Our ref: Coalcliff Eco-Tourist Facilities (SSD-76132994)

18 October 2024

Subject: Coalcliff Eco-Tourist Facilities (SSD-76132994) - Request for Additional Information

Figure 3 Eastern portion indicative site plan (eco-tourism and environmental facilities)

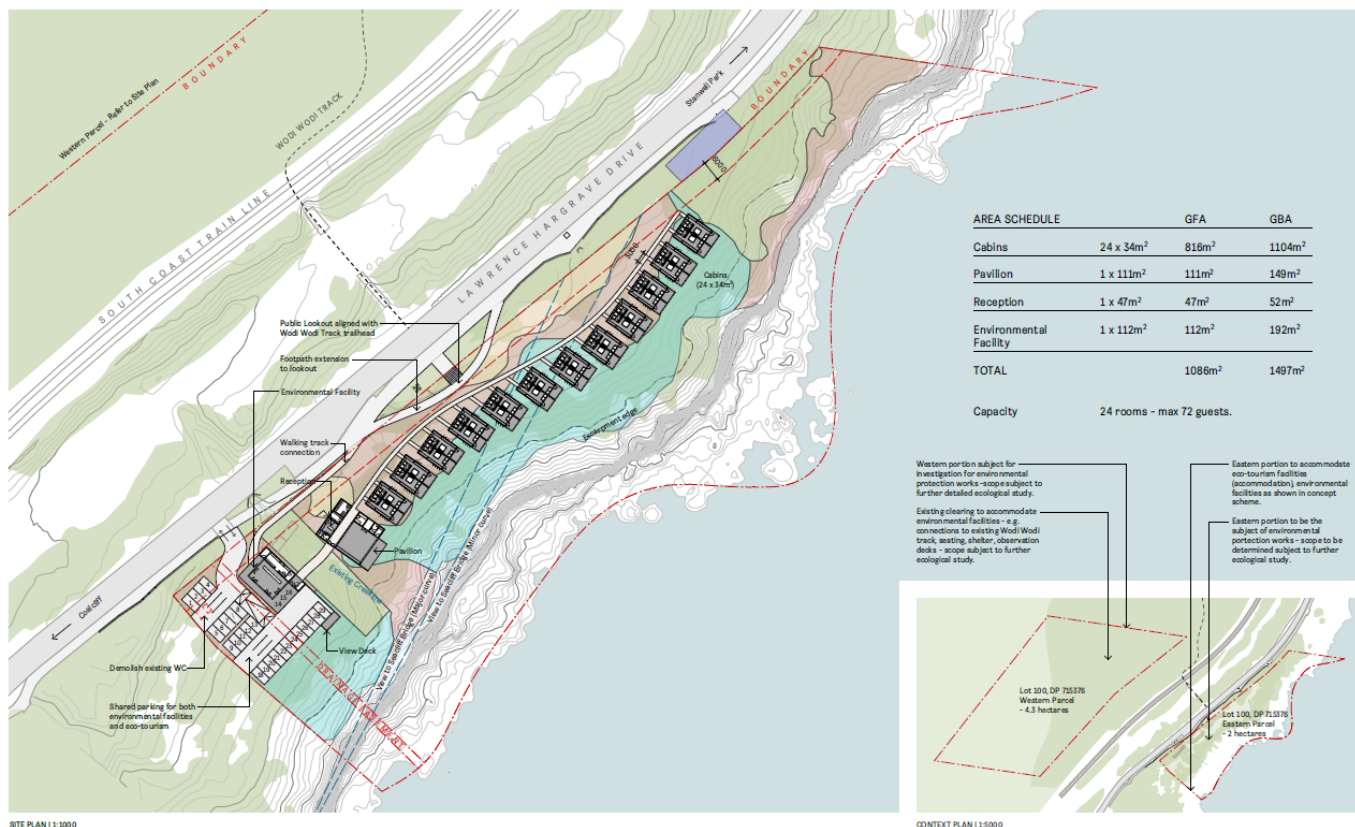
The proposed site configuration is spread out and, in turn, may increase the size of any required Asset Protection Zones and clearing: Section 3.4 Analysis of Alternatives in the scoping report does not adequately address feasible alternatives, or impacts associated with them.
